From: [REDACTED]
Sent: 01 February 2011 13:47
To: Juan Baeza
Subject: RE: The Old Barn AL/124/10 & Westside Supplies BR/341/10

Juan
 AL/124/10

Further to our telephone conversation on Tues 1st Feb we would confirm withdrawal of planning application AL/124/10 whereby we will amend the proposed dwelling to be single storey.
 BR/341/10

Drawing 1 / 5

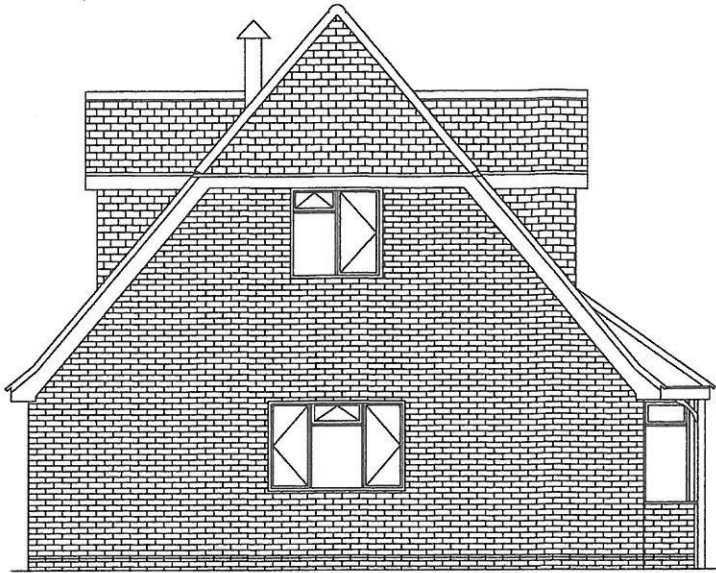
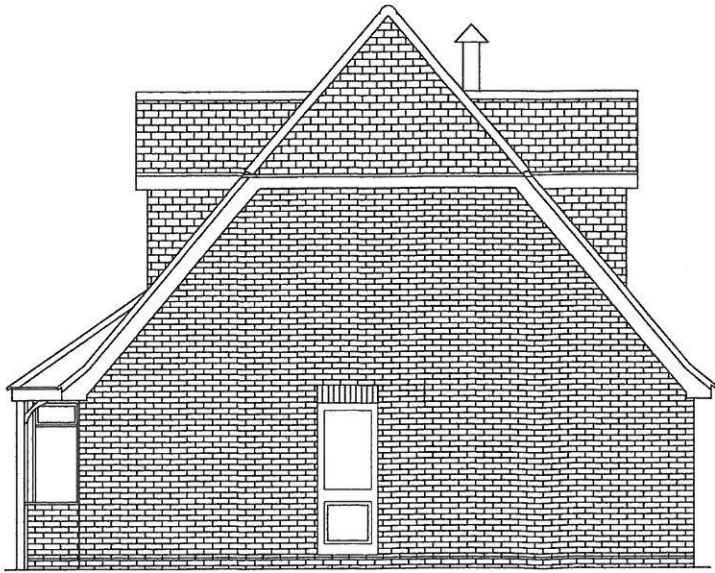
Due to replacement being of a substantially larger footprint and height than exiting dwelling, I am minded to refuse this one in its current form. Will your client be wanting to proceed as it is or withdraw and resubmit?
